Planning Officer: Miss Z Toppin
Planning Application Ref: **AW/253/20/T**
Location: **14 Old Farm Close, Aldwick**
Description of works: **Reduce height of 1No. maple tree to approx. 10m**
Reasons given: To prevent nuisance to public highway users

14 OLD FARM CLOSE

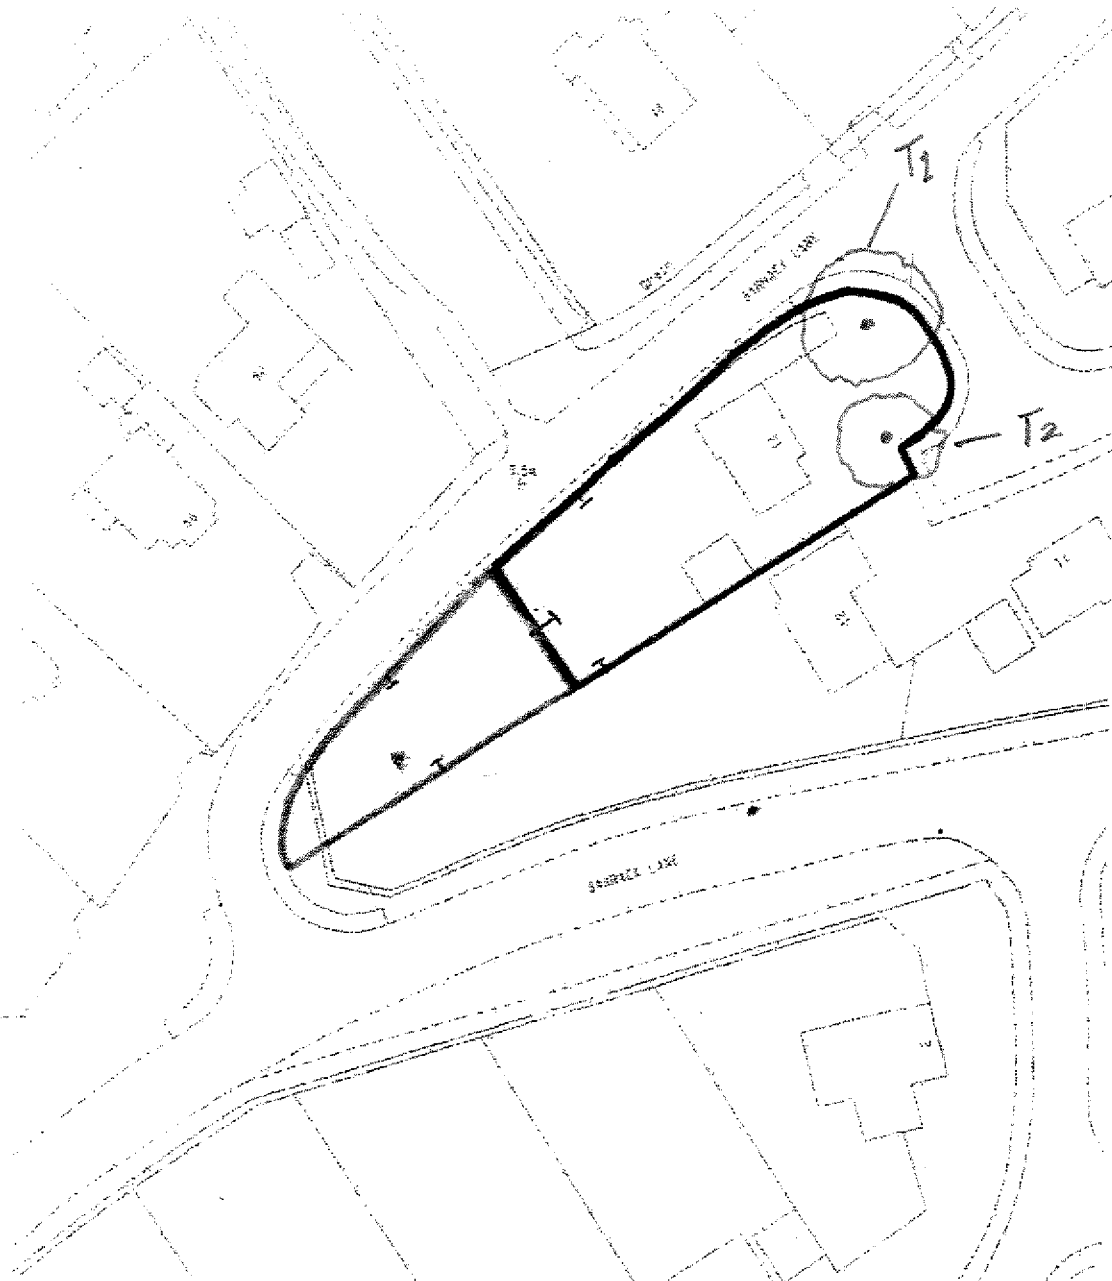
- This tree appears to be outwardly healthy and stable with a relatively unmodified and attractive crown profile.
- It grows at the front of the property and is prominent within the close. It can also be seen by users of the public highway and is of visual interest. It is a tree of high public amenity value.
- Low branches are beginning to encroach the public highway space and will become problematic if left unattended. The applicant proposes a reduction of height and spread, where the removal/reduction of carefully selected low branches would be sufficient to meet the stated aim without introducing structural weakness to the limb/branch framework at height and committing tree owner(s) to regular and costly future maintenance pruning.
- It is perhaps the finest one of three silver maple in close formation that collectively are an impressive arboricultural feature.

- The tree is a significant feature in the local landscape and appears to be in adequately sound and healthy condition. Although well-intentioned, the tree surgery proposed in the application would result in excessive reduction of the tree's landscape impact and undue detriment to the visual amenities of the locality. *Crown lifting* operations (lesser works) can ensure the applicant discharges their 'duty of care' whilst preserving the visual amenity of the tree.

- As it stands, I am unable to recommend approval for this application.

- I would like to see the applicant agree to a revision of their work proposal for this application, such as detailed below, which would seem to address their concerns whilst preventing a diminution of the tree's landscape and public amenity value:
 - Crown lift to achieve a maximum of 2.5metres overhead clearance above the footway.
 - Crown lift to achieve a maximum of 5.5metres overhead clearance above the carriageway.
 - Reduce/removal small diameter branches on SW aspect only, to give understorey trees/shrubs adequate room to grow-on, not exceeding 2metres clearance. No final pruning cut to exceed 25mm in diameter.

- Part a) Where whole branches are to be removed and final cuts made close to the trunk or branch union they are to be made as shown in Figure 2 of BS3998:2010
- Part b) Where branches are to be shortened back the final cuts are to be made at the correct angle shown in BS3998:2010 and adjacent to a live bud or lateral.
